From: Kathryn Welch

Subject: Y/10/26/PL Rookery Farm

Kathryn Welch
Senior Planning Officer, Planning Department

2601_200_PL0
*** PROPOSED DRAWINGS**

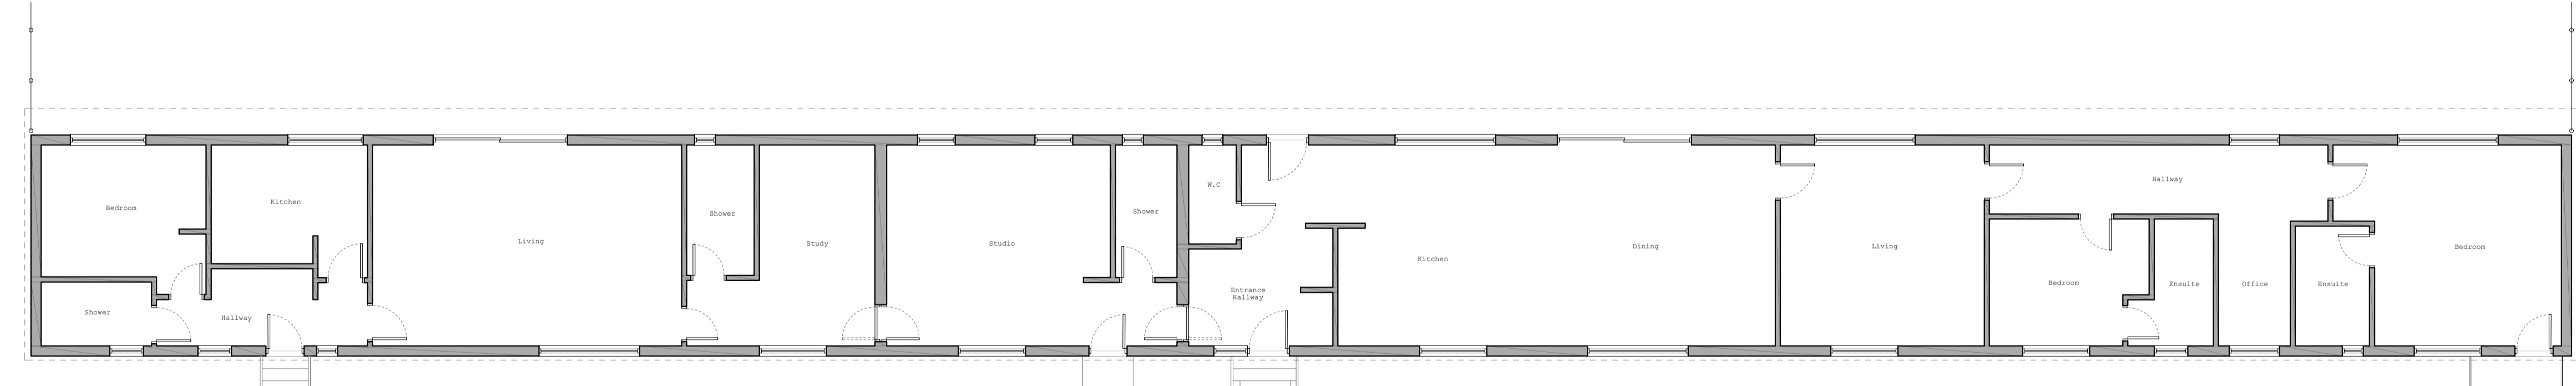
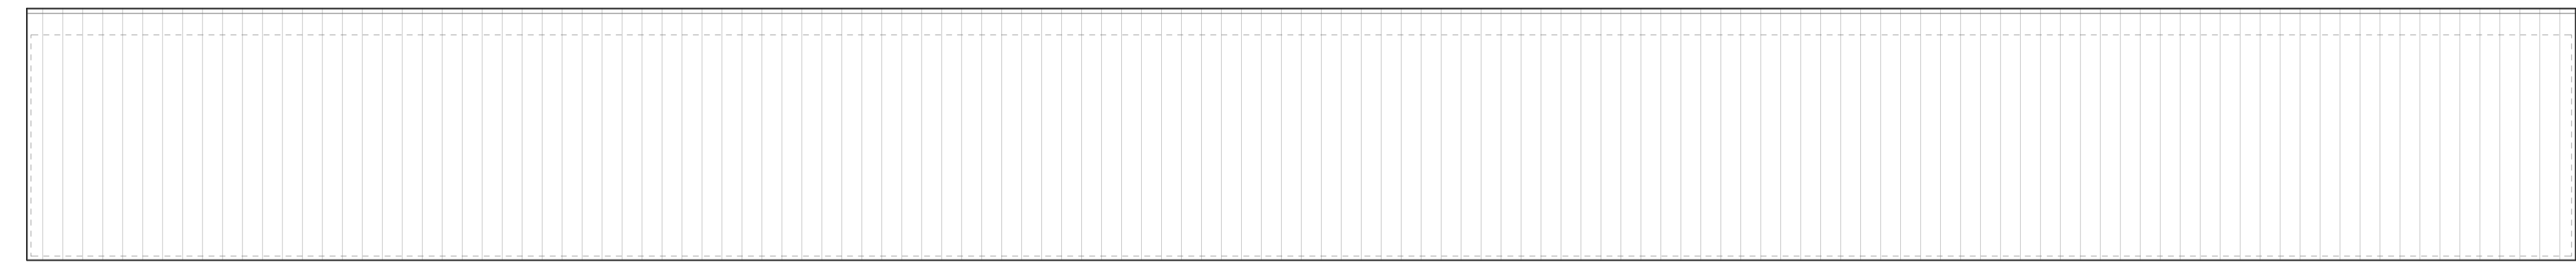
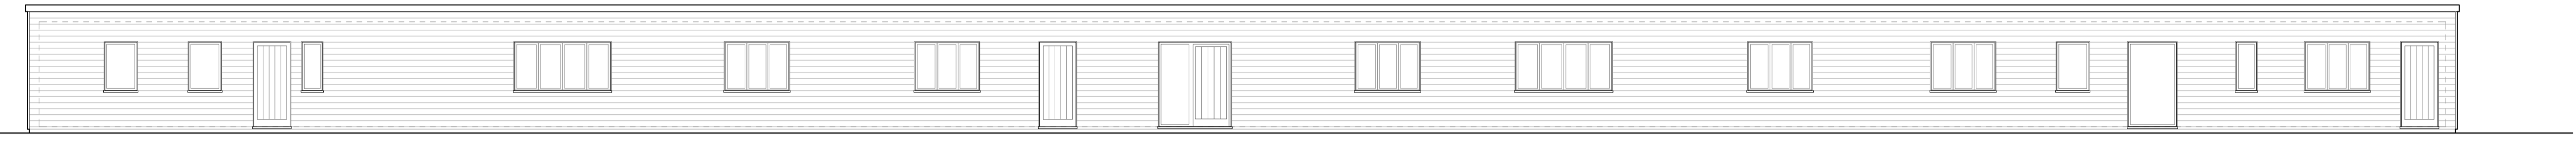
With regard to the number of dwellings on the site, I consider it evident that; despite the interconnectivity, the building has been designed to function as up to three separate dwellings. Evidence observed on site, including the number of front doors, subdivision of the land, and the number of ASHP units, has informed this view. I have also been provided with a Building Control report which confirms that the structure was designed as three separate dwellings for the purposes of fire-spread regulations.

Finally, I noted during my visit that construction of a pergola has commenced at the rear of the property. Given the scale of this structure, I would recommend including it within the submitted plans.
